Application reference number	2024/0097
-------------------------------------	-----------

Application Type	Outline with all Matters Reserved
-------------------------	-----------------------------------

Proposal Description:	Outline application with all matters reserved for residential development
Location:	Land off Grange Crescent, Thurnscoe, Rotherham

Drawing No.	Rev No.
MNV001 -001

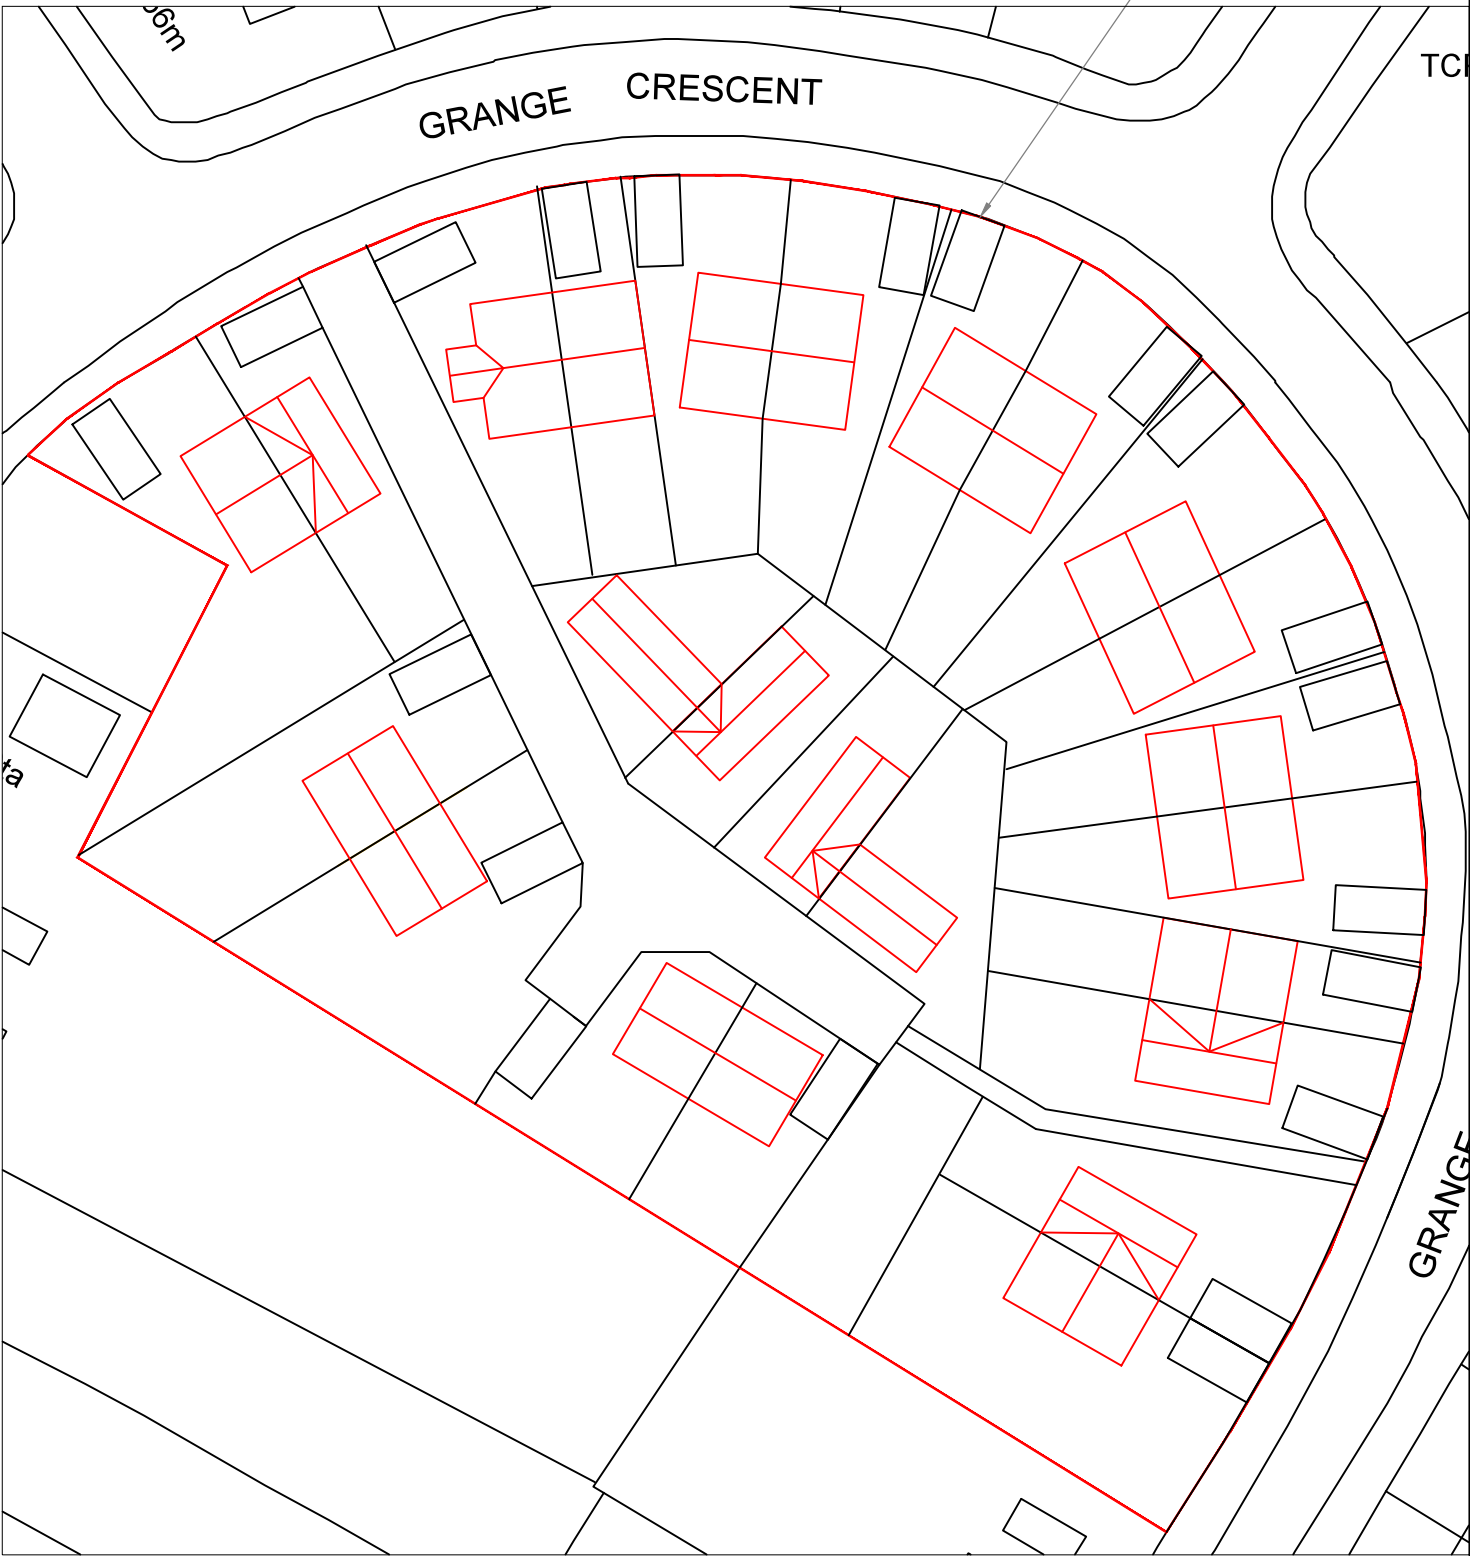
Given the application is outline only the Highways Officer has no objection to the principle of development, however, the indicative plan submitted would not be a suitable layout in terms of highway safety for the reasons given below:

- Off-street parking should be provided at a rate of one space per property of one or two bedrooms and two spaces for properties with three or more bedrooms. As such, the proposals may be low on parking if the dwellings are anticipated to be larger.
- No visitor parking has been shown and this should be provided at a rate of one space per four dwellings.
- Visibility splays from the proposed new driveways would have to be demonstrated as being a minimum of 2.4m x 43m from each drive onto Grange Crescent.
- The proposed new shared access appears to serve more than five plots and would therefore have to be constructed to adoptable standard. The present design is too narrow, has no provision for pedestrians, and is unlikely to be able to safely turn a refuse vehicle. Visibility would again have to be demonstrated.

Highways would require a significant change to the layout at Reserved Matters stage and to facilitate this, highways have requested a number of conditions to be included to the decision notice.

4. No development shall take place until a scheme detailing arrangements and specification for layout and parking have been submitted to and approved in writing by the Local Planning Authority. Before any building is occupied the development shall be completed in accordance with the details shown on the approved plans and retained thereafter.
